WEST SUSSEX COUNTY COUNCIL CONSULTATION

TO:	Arun District Council FAO: Amy Myer
FROM:	WSCC - Highways Authority
DATE:	3 August 2020
LOCATION:	29 Highcroft Crescent, Bognor Regis, PO22 8DH
SUBJECT:	BR/139/20/PL Re-establishment (sub-division) of dwelling to form former pair of semi-detached bungalows.
DATE OF SITE VISIT:	N/A
RECOMMENDATION:	Advice
S106 CONTRIBUTION TOTAL:	N/A

block plan
1:500

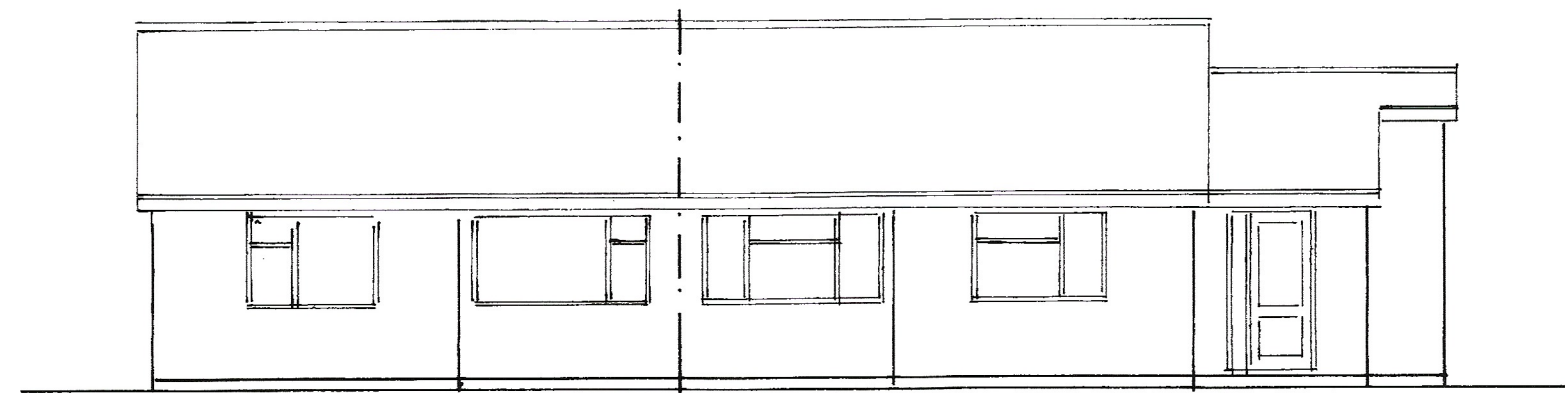
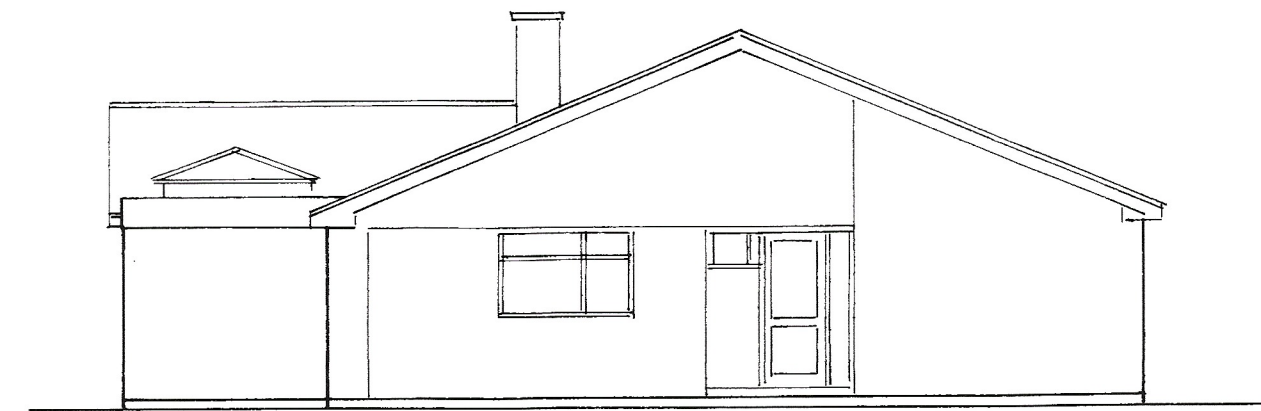
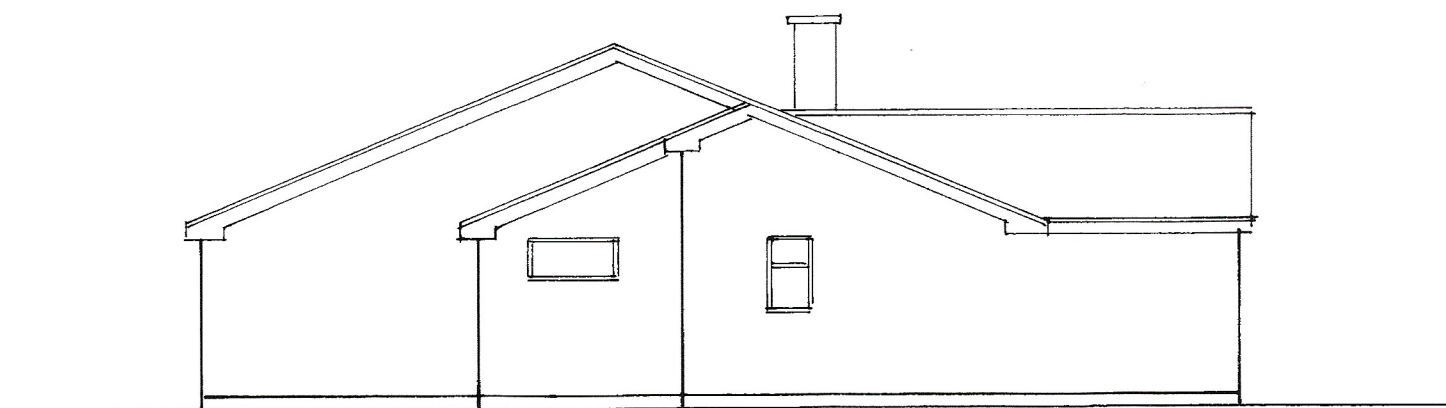
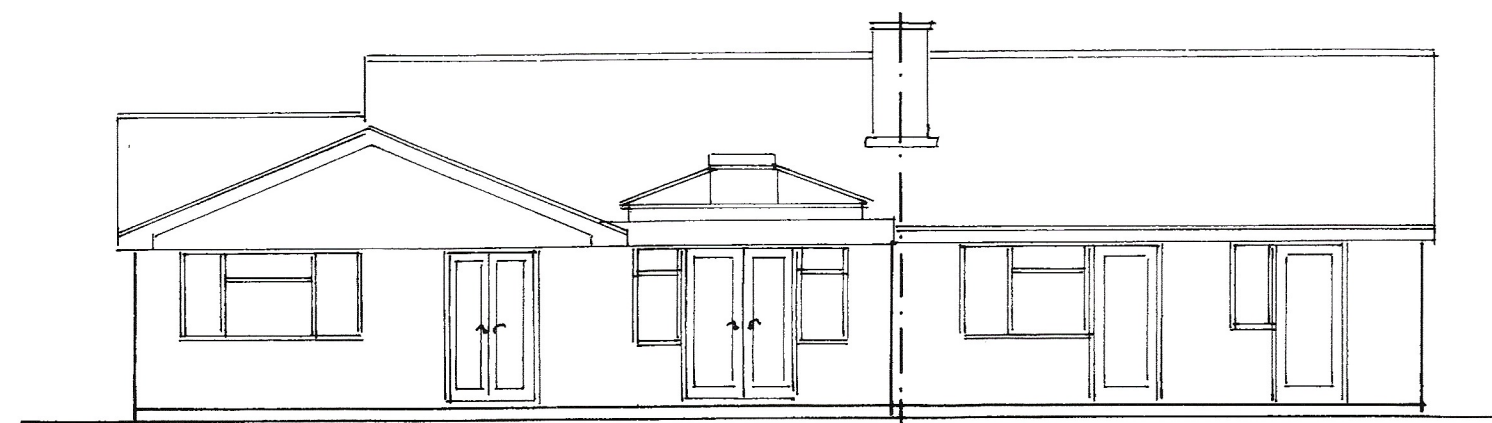
The site currently benefits from two existing accesses on Highcroft Crescent. The applicant proposes no alterations to the existing access arrangement. There are no apparent visibility issues at these access points. An inspection of collision data provided to WSCC by Sussex Police from a period of the last five years reveals no recorded injury accidents within the vicinity of the site. Therefore, there is no evidence to suggest the existing accesses are operating unsafely or that the proposal would exacerbate an existing safety concern.

The applicant proposes to utilise the existing driveway for vehicular parking. Under Arun Parking Standards, a development of this size in this location would require three car parking spaces. From inspection of the plans, there appears to be sufficient space within the driveway for this parking demand to be accommodated.

On-site turning does not appear achievable, so vehicles may have to exit the site in a reverse gear. However, this is the existing arrangement, which has operated with no known highway safety concerns.

The applicant has not demonstrated cycle parking provision. Cycling is a viable option in the area and the LHA would like to see cycle parking being implemented, in accordance with WSCC and Arun Parking Standards. The inclusion of secure and covered cycle parking provision helps promote the use of sustainable alternative modes of transport to the private car.

No part of the development shall be first occupied until the car parking has been constructed in accordance with the approved site plan. These spaces shall thereafter be retained at all times for their designated purpose.

No part of the development shall be first occupied until covered and secure cycle parking spaces have been provided in accordance with plans and details to be submitted to and approved by the Local Planning Authority.
